Our ref: AN/2024/135649/03-L01
Your ref: H18-0463-24
Date: 22 October 2024

Change of use from hotel Class C1 to residential Class C3 including the creating of 15 residential units
Bridge Hotel, 4 Bridge Road, Sutton Bridge, Spalding, PE12 9UA

Environment Agency position

PROJECT:	4 Bridge Rd, Sutton Bridge, Spalding, PE12 9JJA
DATE:	30/07/2024
SCALE:	As shown @ A1 Do not scale from drawing
DESIGNER:	PLANNING
DRAWN BY:	EH
CHECKED BY:	JC
CLAYTON ARCHITECTURE LIMITED	CLAYTON ARCHITECTURE LIMITED

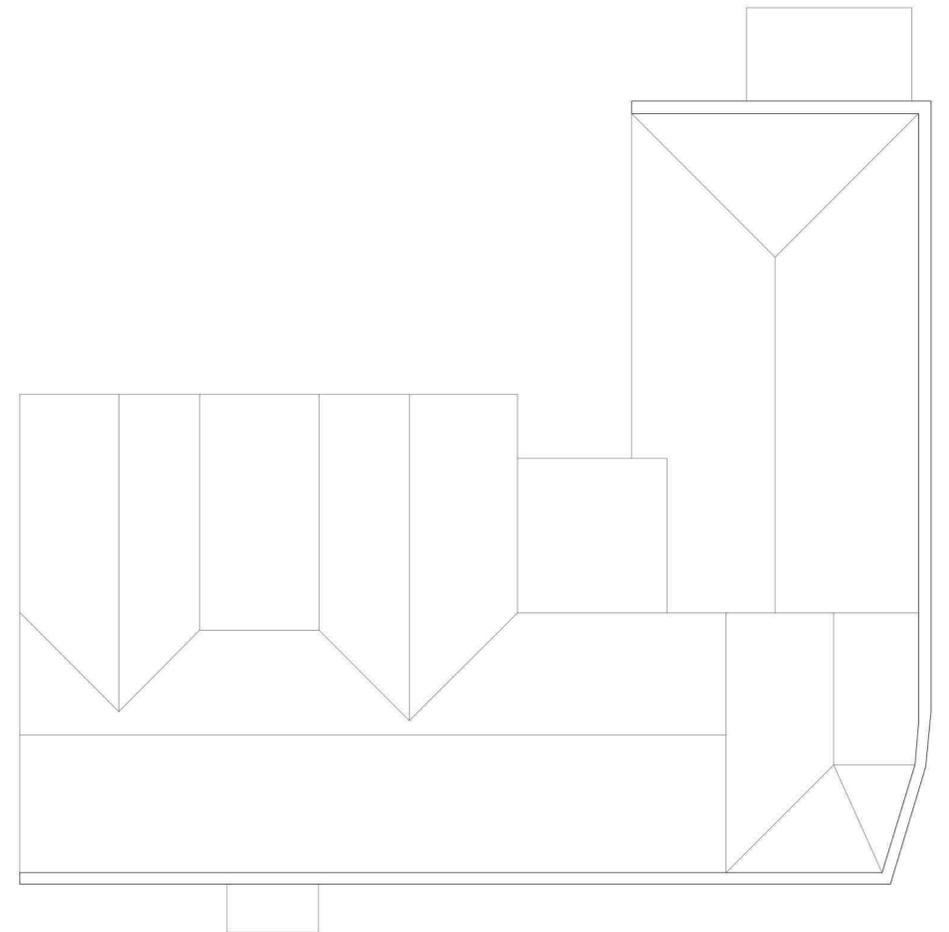
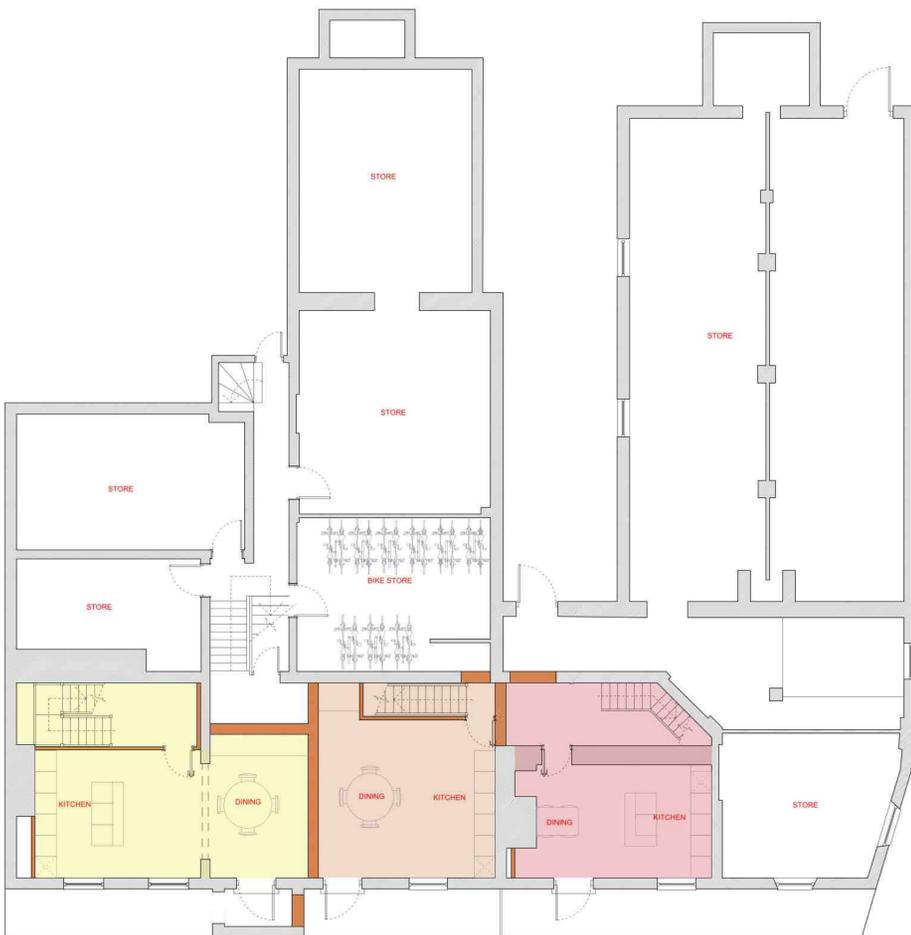
We have reviewed the amended proposed floor plan drawing and consider that it satisfactorily addresses our earlier concerns.

The development shall be carried out in accordance with the submitted flood risk assessment dated 23 July 2024, ref: 'Proposed Change of Use from hotel to Residential Use at the Bridge Hotel', prepared by S M Hemmings and the submitted drawing dated 30 July 2024, ref: '723-04-E', prepared by Clayton Architecture Ltd, and the following mitigation measure they detail:

- Finished floor level of the ground floor living accommodation shall be set no lower than 7.25 metres above Ordnance Datum (AOD)

The basement level of the properties hereby approved shall be used as non-habitable accommodation, including the uses of garage, WC, utility and bath/shower room only and for no other habitable accommodation.
